# MONA OFFSHORE WIND PROJECT

## Response to Conwy County Borough Council and Denbighshire County Council D4 Submission

Application Reference: EN010137

Document Reference: S\_D5\_5

Viewpoint CMP 1: View southeast from Denbighshire Memorial Park and Crematorium (OS Grid Ref: 301084, 373837)

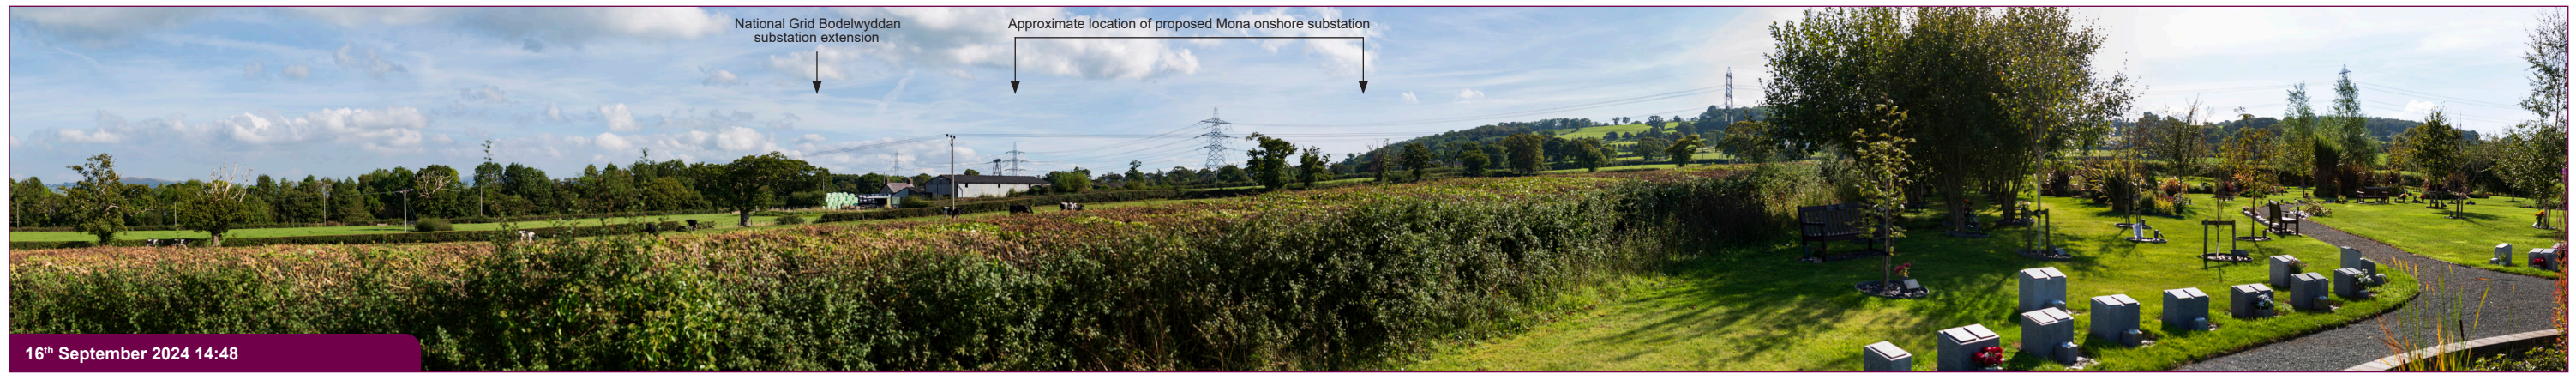
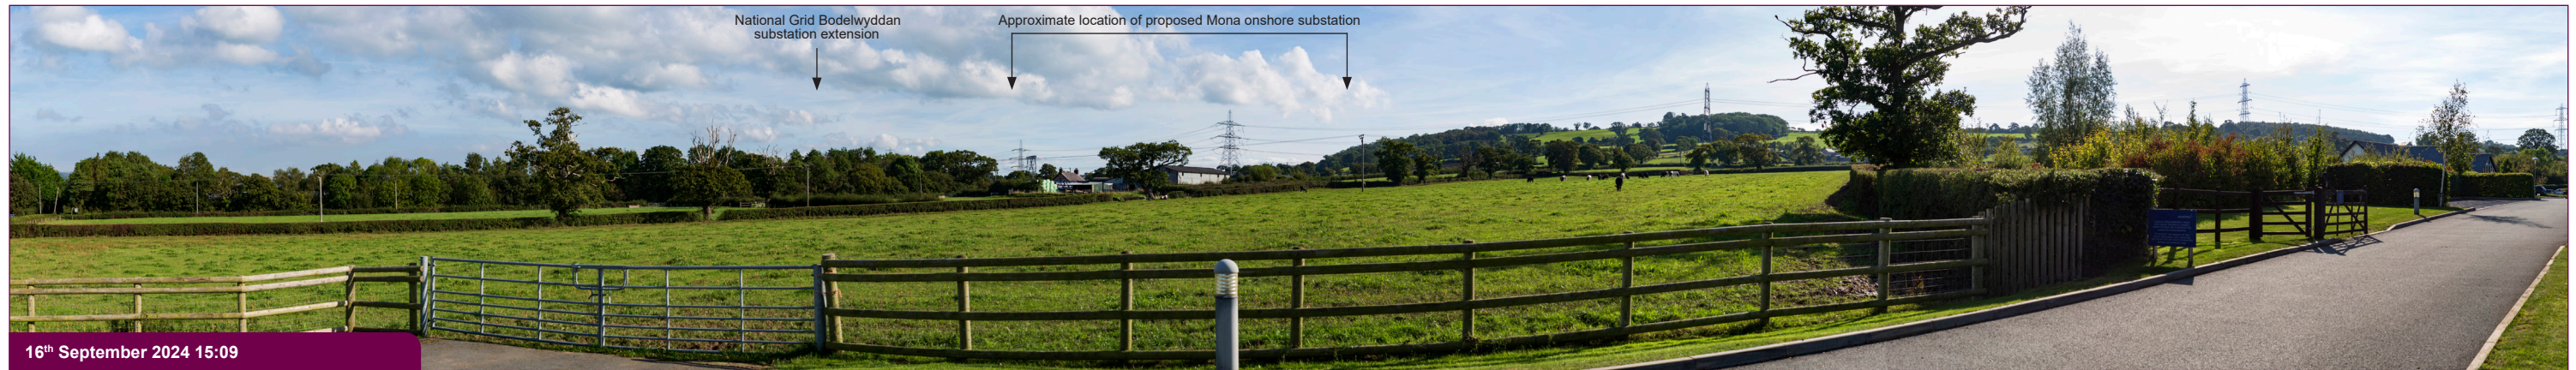
REP4-096.11	4. The Onshore Substation	viii. Mr Oakman set out that through the Statement of Common Ground process, discussions with the Applicant on their further work including a site visit and photographs, has resulted in an agreement that they would provide an annotated set of those photographs at some point during the examination process, and that they would accompany that with an assessment of the effects on the visual effects on of the users of the crematorium.	Mr Oakman requested that the photographs from viewpoints at the Denbighshire Memorial Park and Crematorium were annotated to show the location of the Onshore Substation. The Applicant provided, the annotated photographs at Deadline 4 (REP2-085).
